From: Nick Fterniatis <Nick.Fterniatis@shfa.nsw.gov.au>
To: "Michael.Buckley@planning.nsw.gov.au" <Michael.Buckley@planning.nsw.gov....>
Date: 19/10/2010 2:58 pm
Subject: Comments on MP 09_0044 for DoP's information

Project Application (MP 09_0044) Park Hyatt Hotel, 7 Hickson Road, the Rocks
Alterations and additions to, and refurbishment of, the existing hotel.

Officers from the Foreshore Authority's Heritage and Urban Design Team have provided the following comments for your information:-

PROPOSED ROOF PLAN
SHEET 2 OF 2

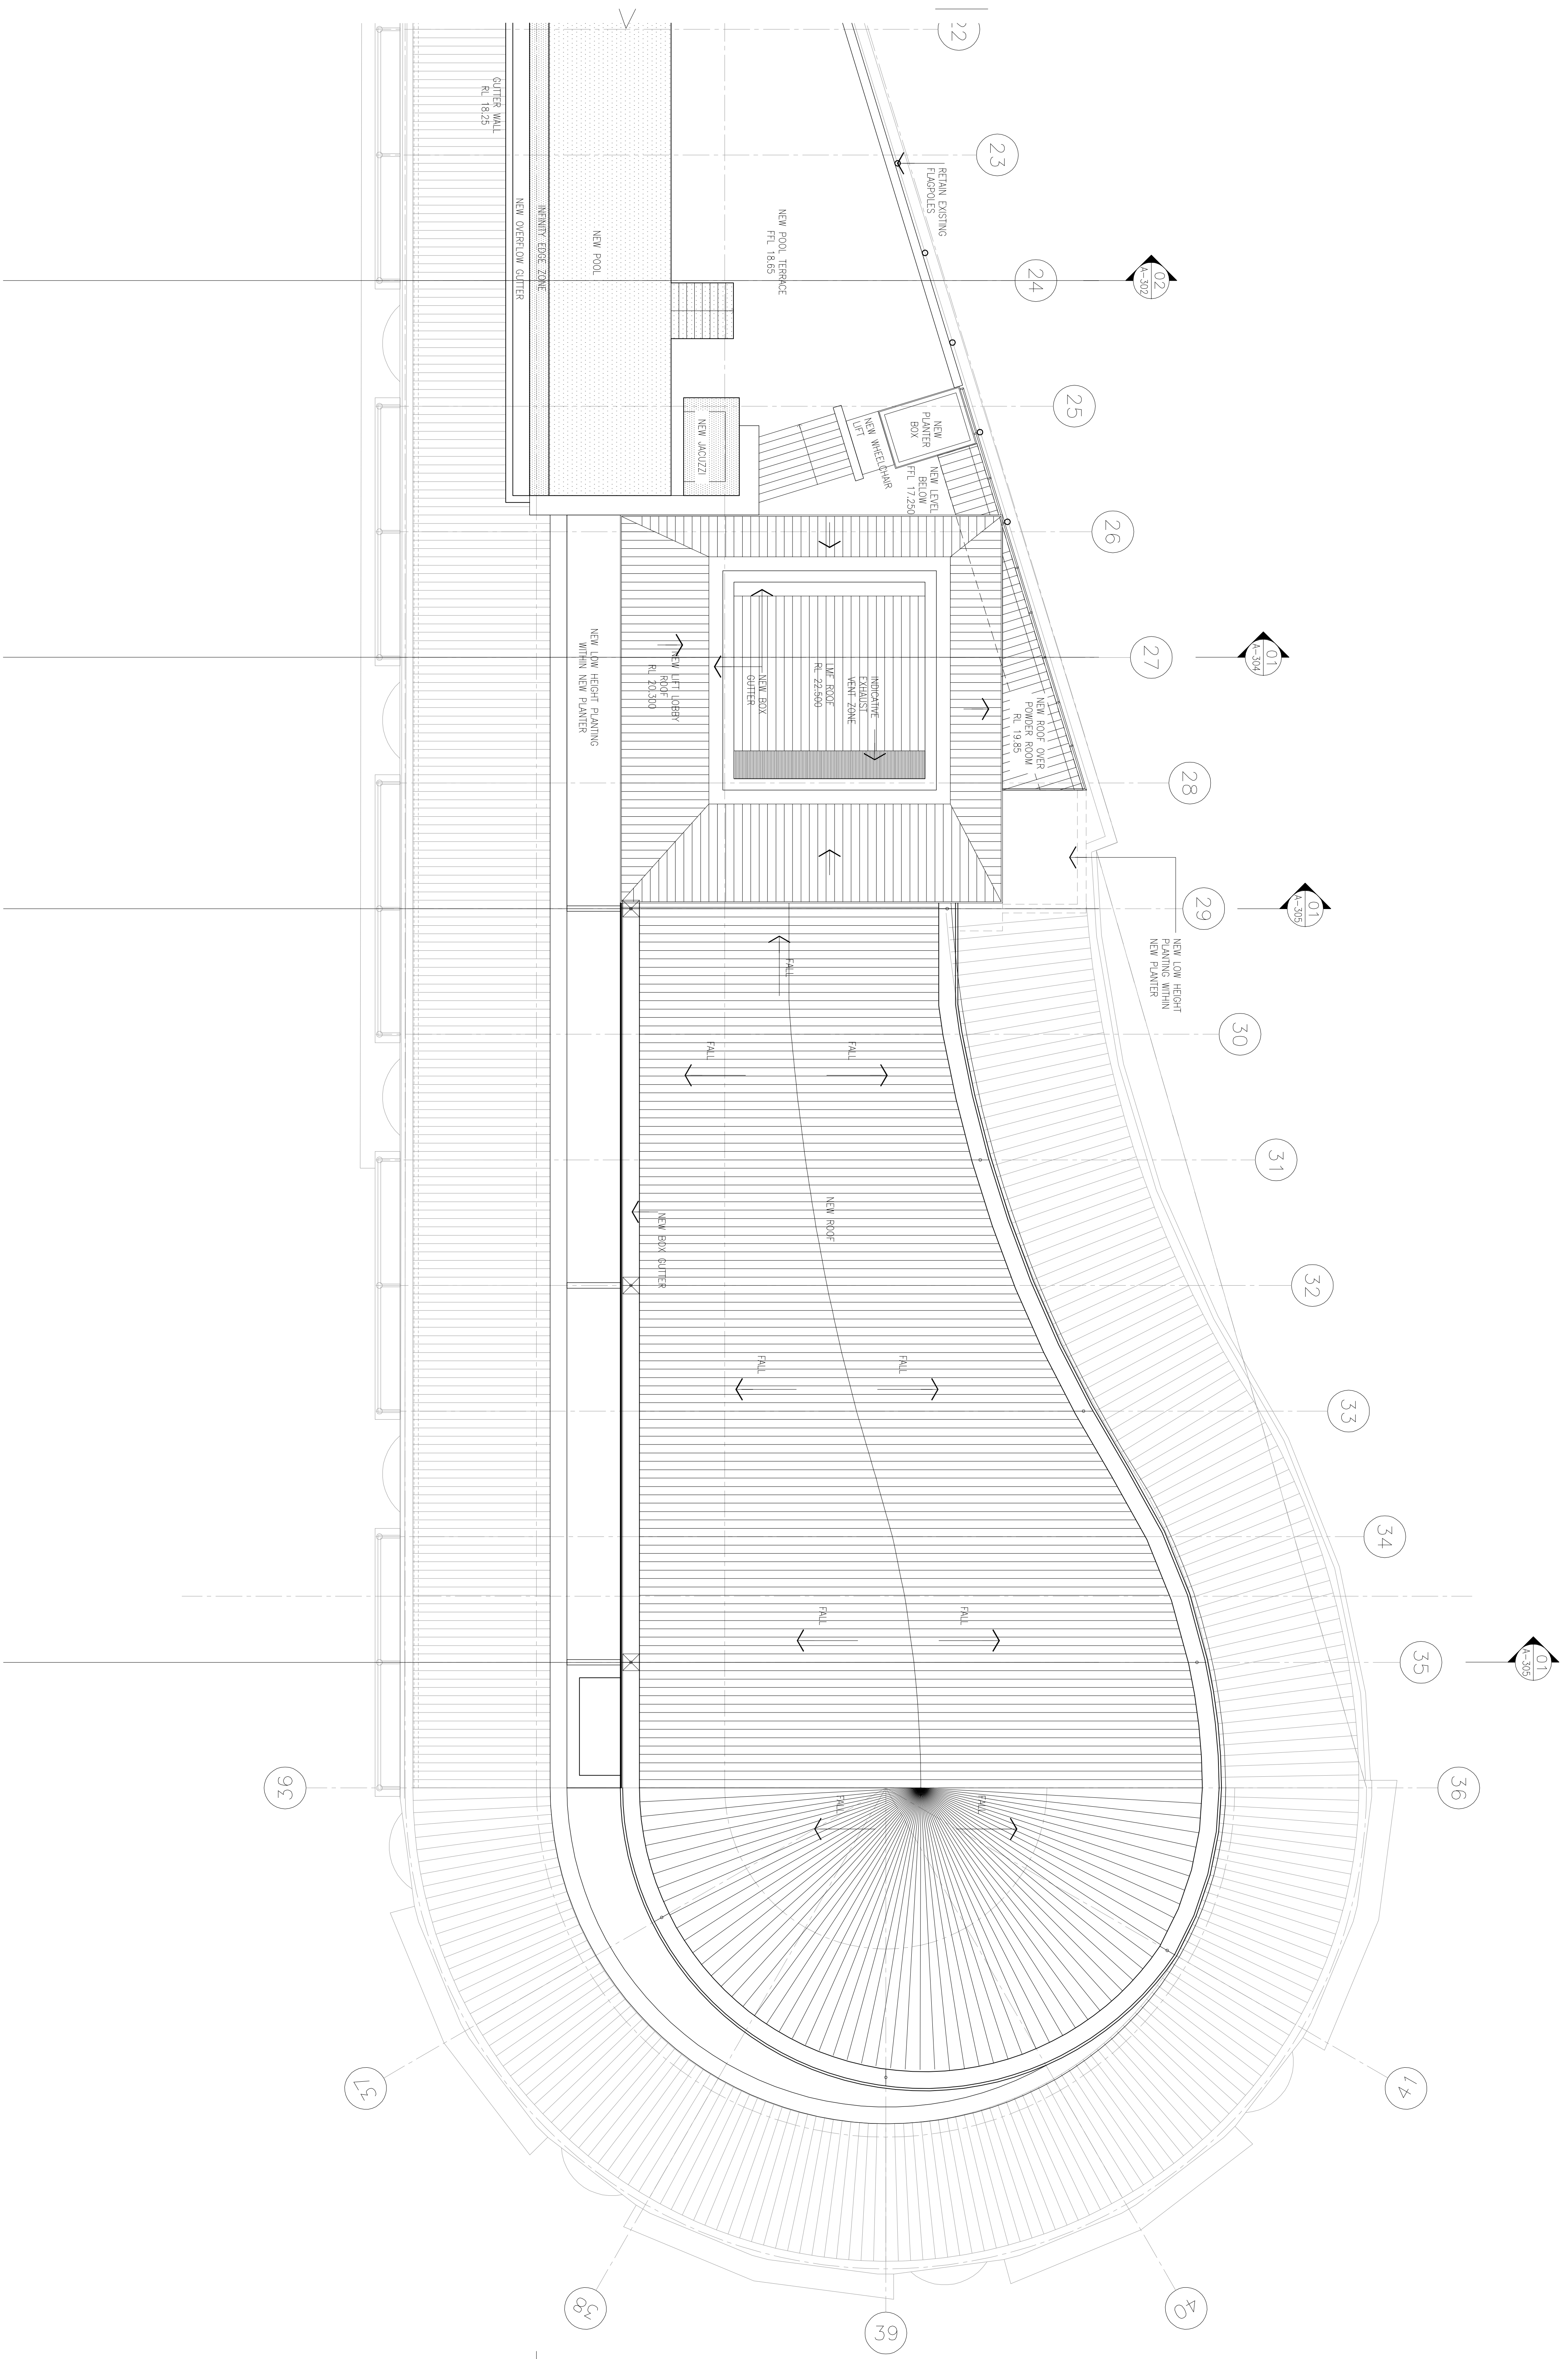
- We noted our preference to increase the setback of the new rooftop elements to Hickson Road, in order to emphasise the existing masonry facade and lessen the visual impact of these new elements. The applicants indicated that further setback is not possible as existing fire stairs have determined the proposed design.

- We requested that the visual impact of shading and artificial lighting for the proposed rooftop terrace and pool should be addressed. No sunshading elements were shown on the drawings, although there are currently umbrellas, and the applicant acknowledged that these will be required. The applicant has agreed to prepare details of the proposed sun shading and a lighting plan. The Authority requested that management comments are included, indicating that elements such as rooftop umbrellas will not remain permanently in place, and will be stored when not in use.

We support the design intent of the changes to the roof form from the current approval, in order to simplify and streamline the roof form, and note that there is a reduction in height at the eastern end, and an increase in height at the western end.

DRAWING TITLE
DETAILED ELEVATIONAL STUDIES 2

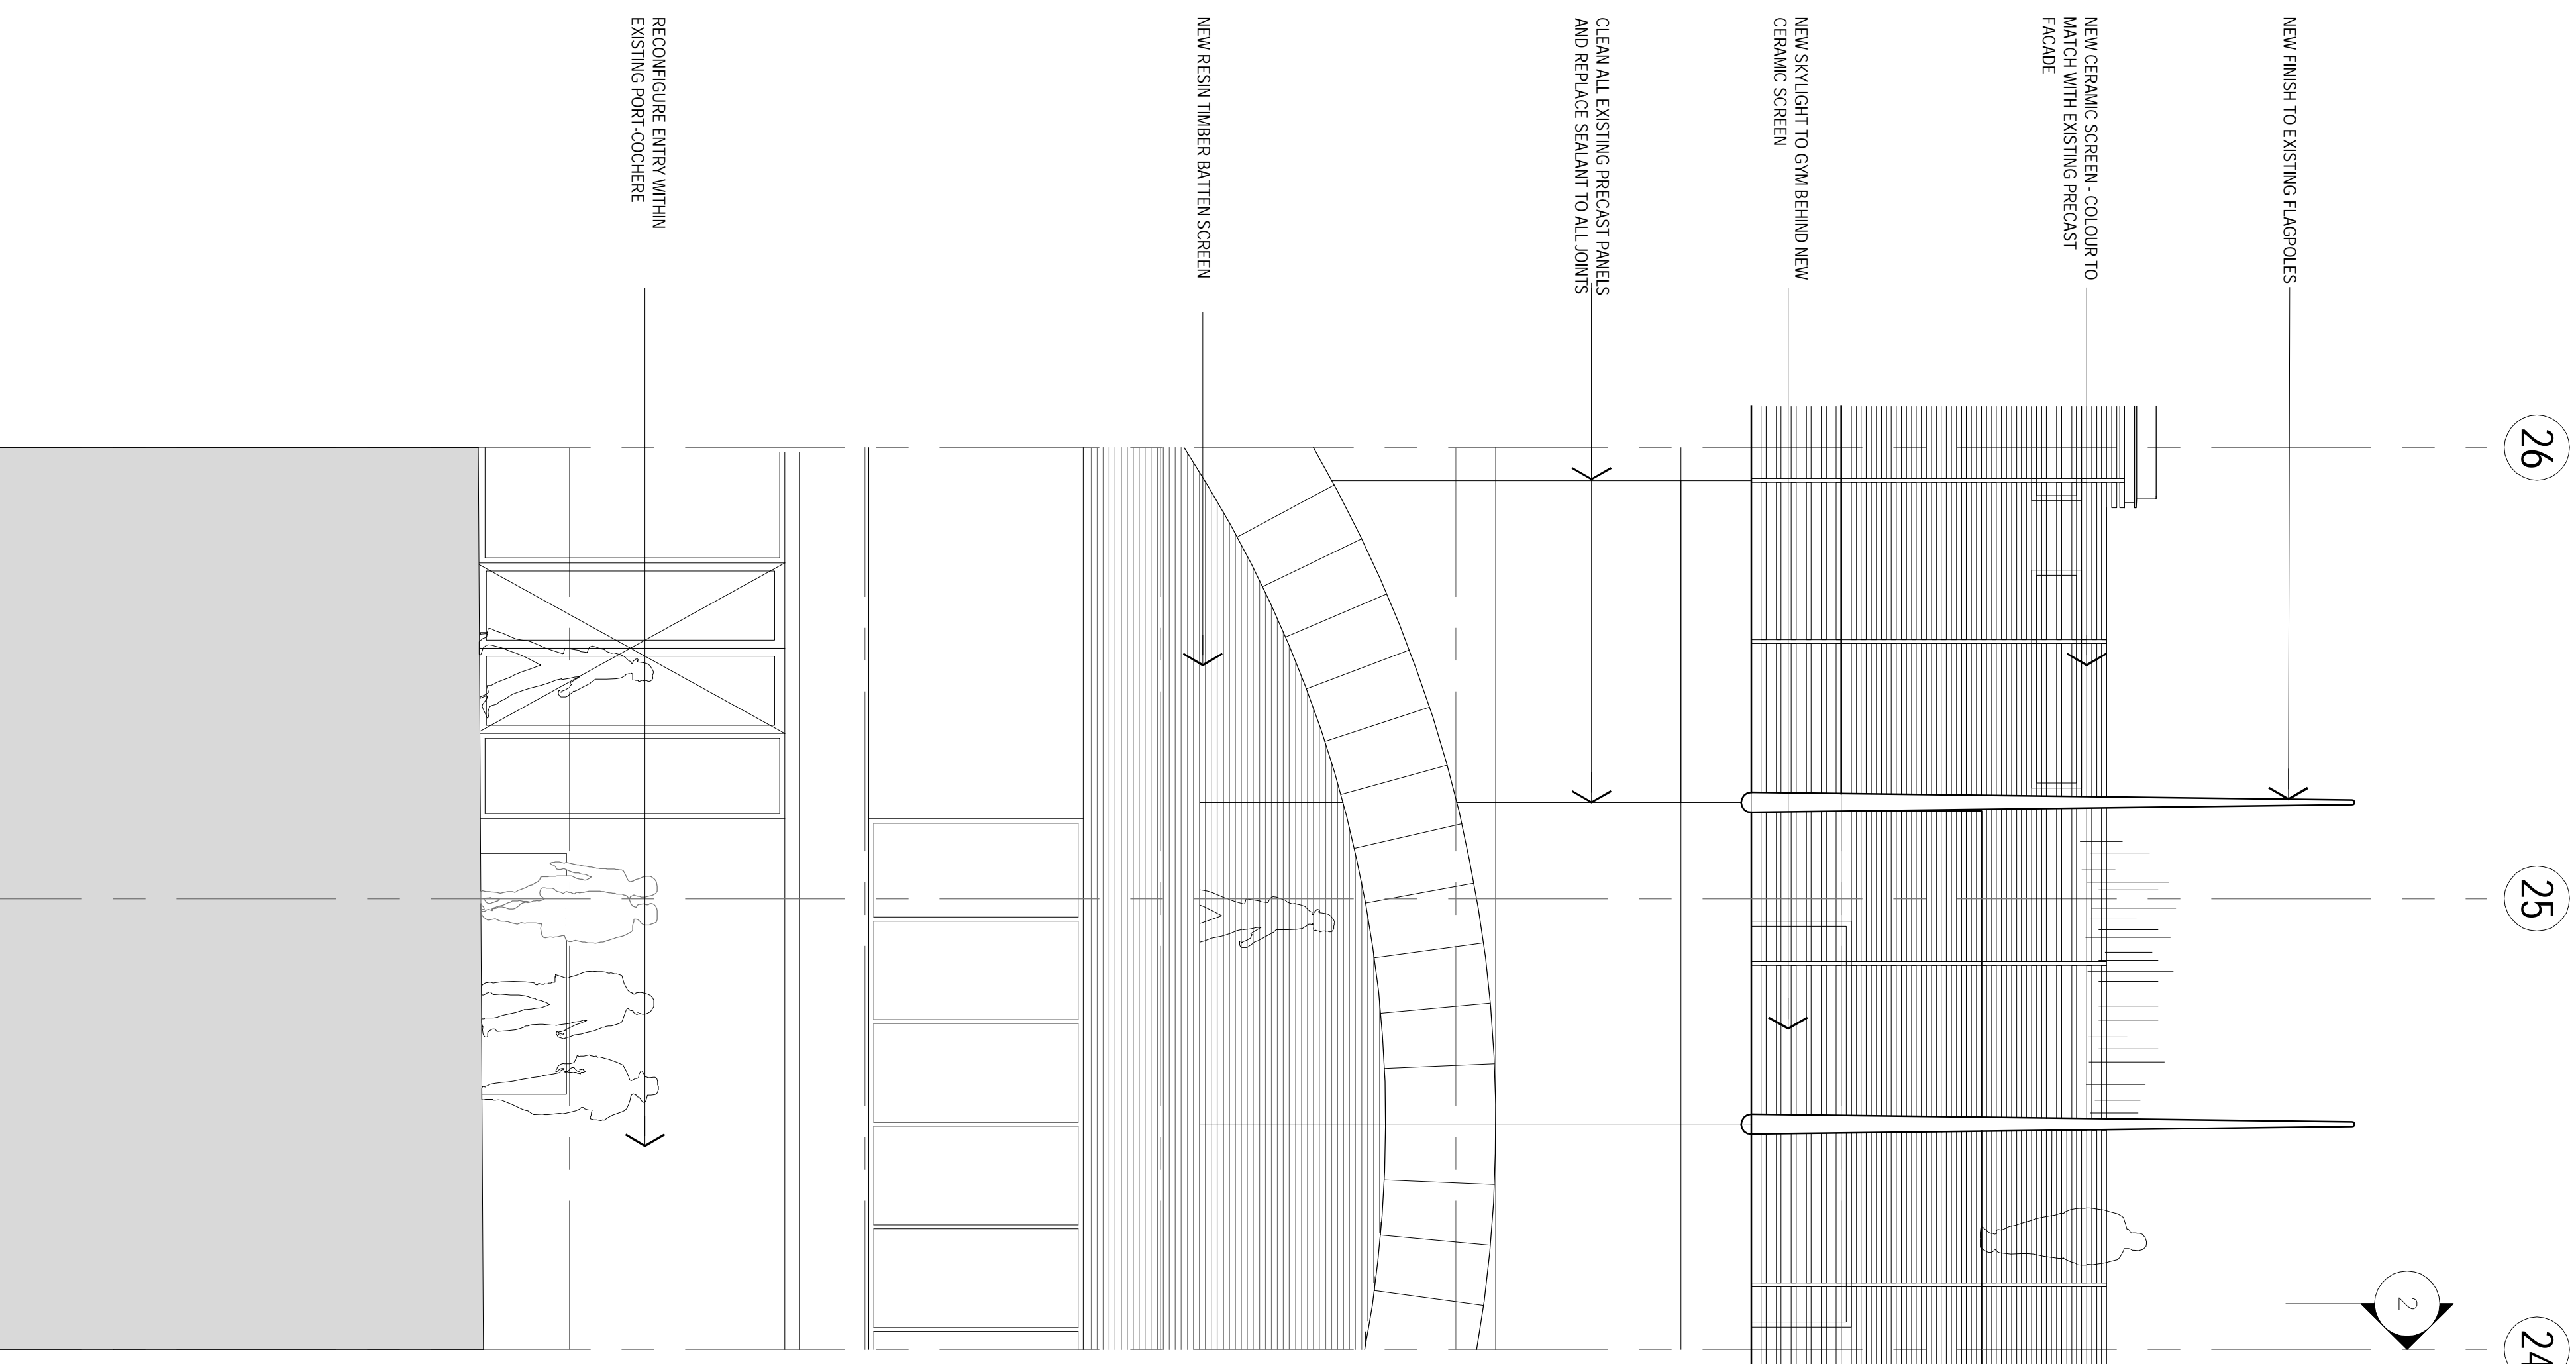
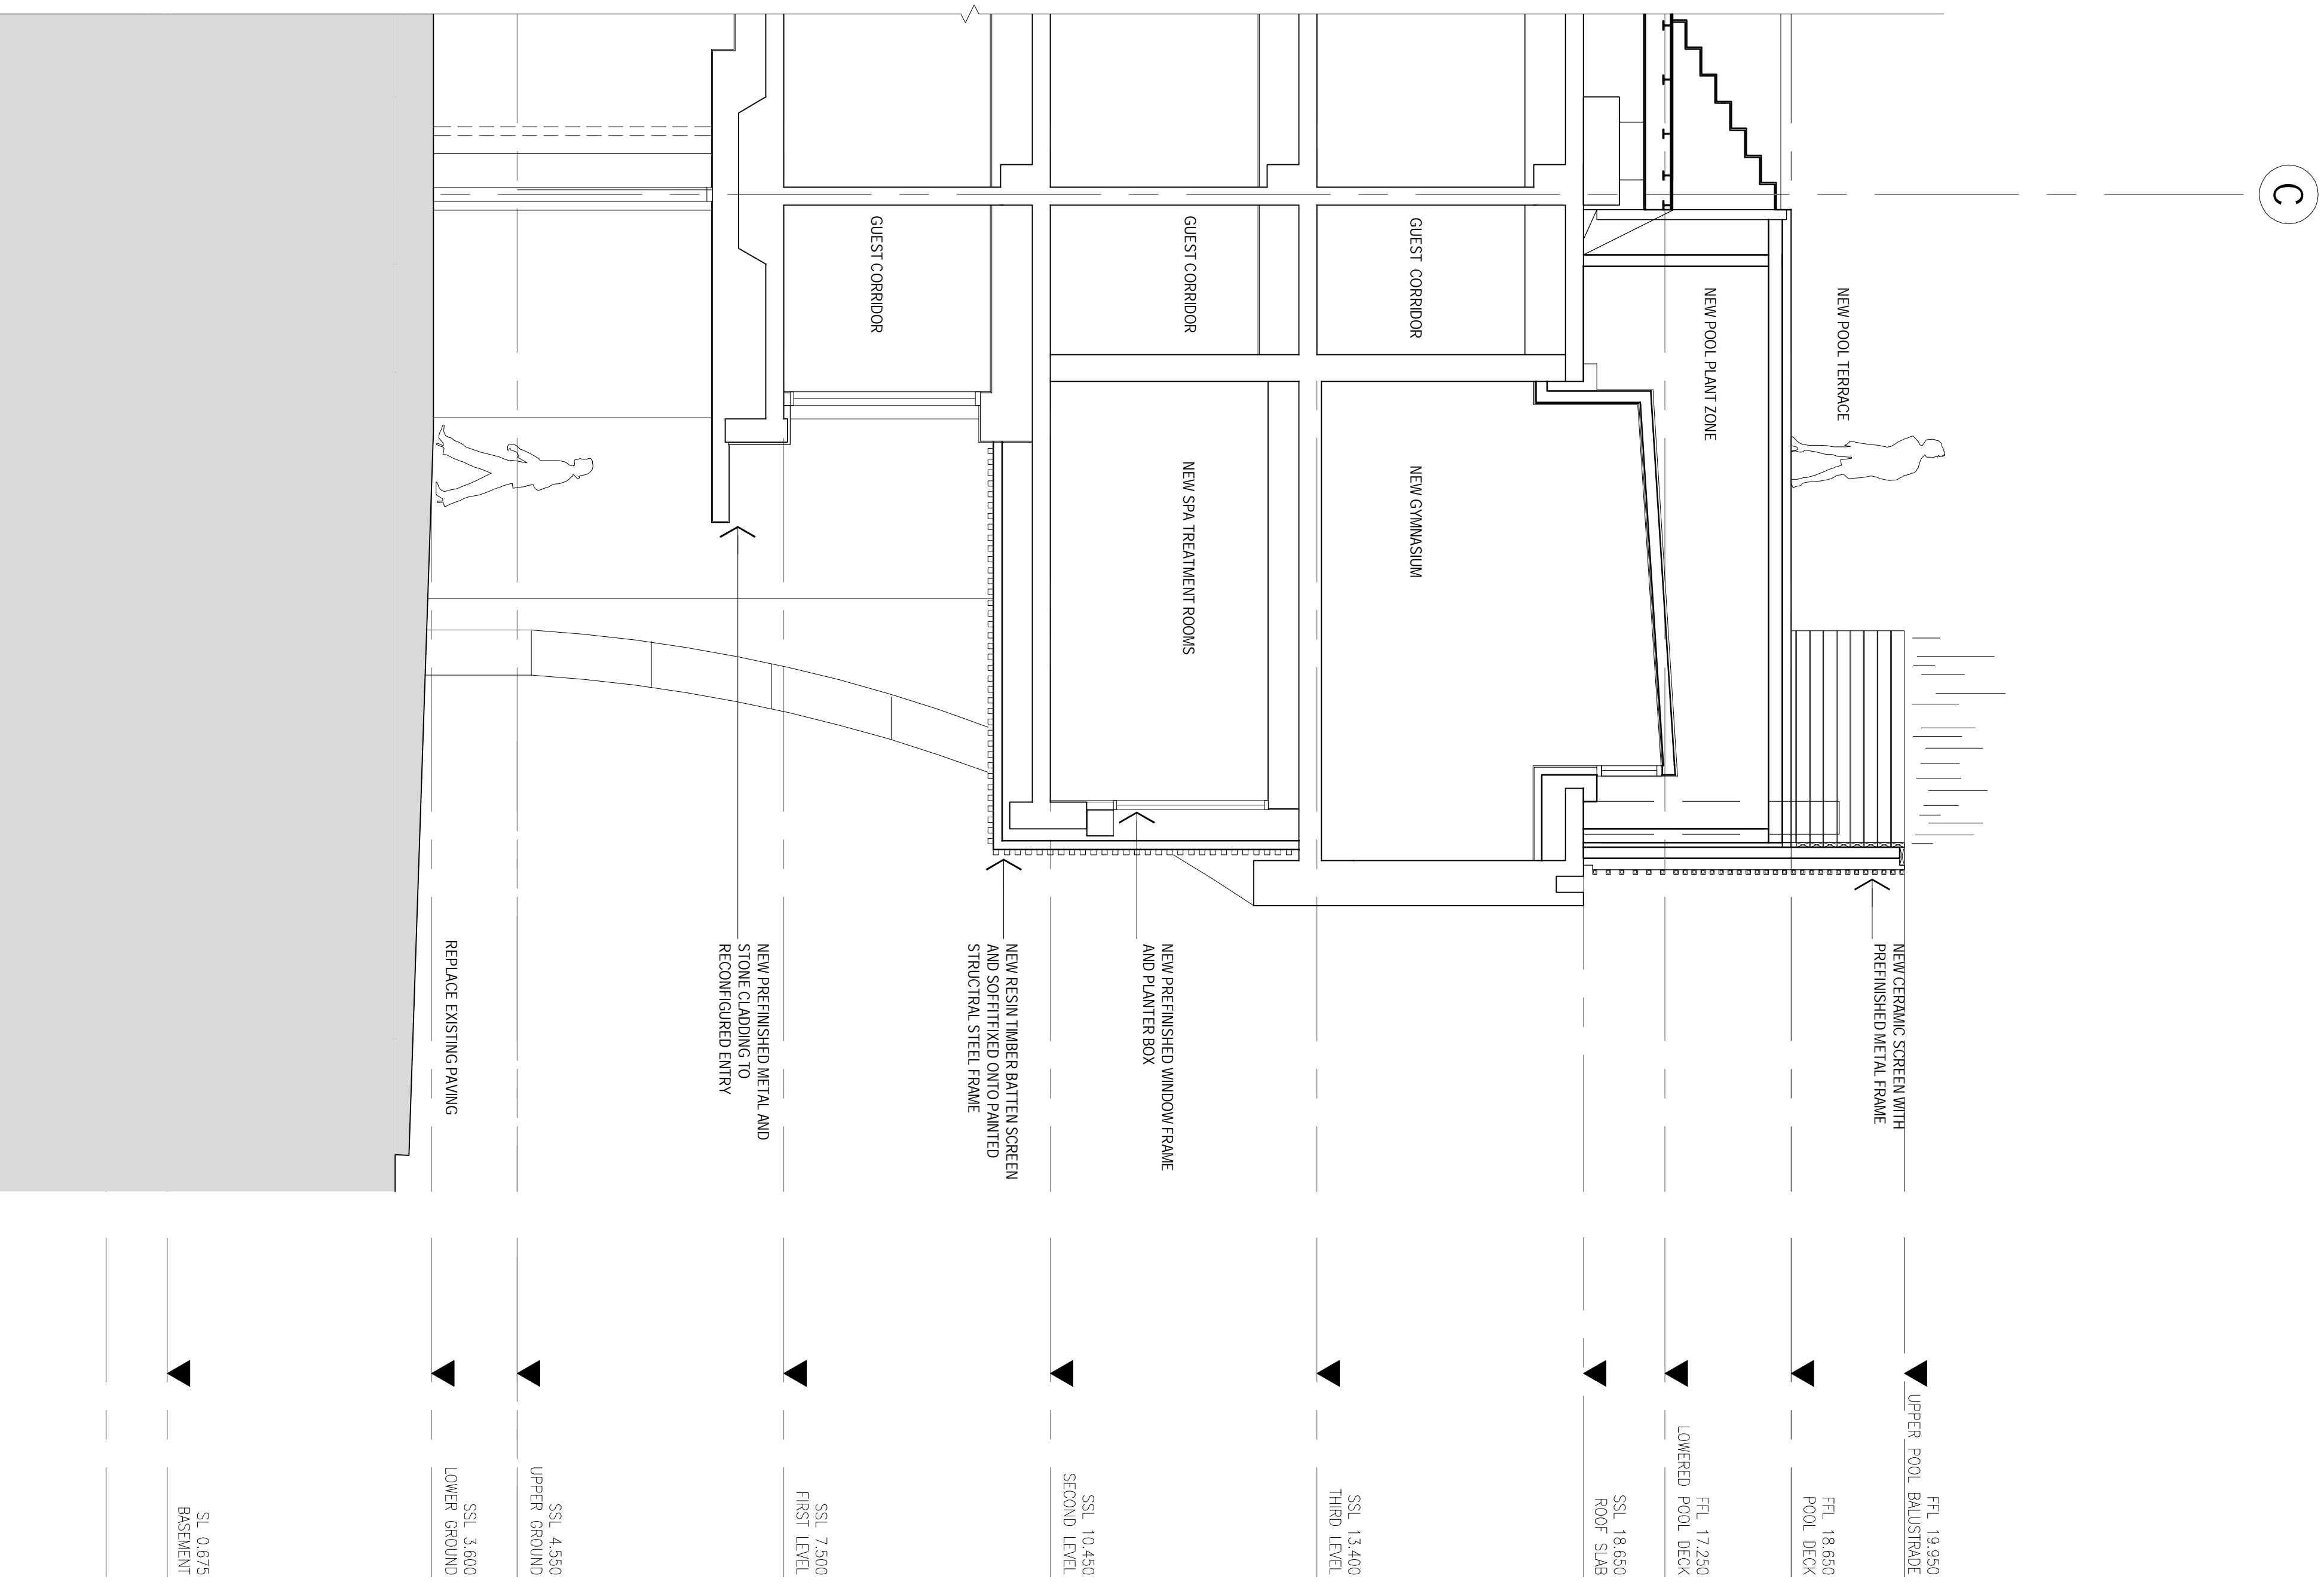
As noted above, we queried the form of the proposed new battened screening along the northern Hickson Road edge above the arched entry, and would like further options to be developed for this location.
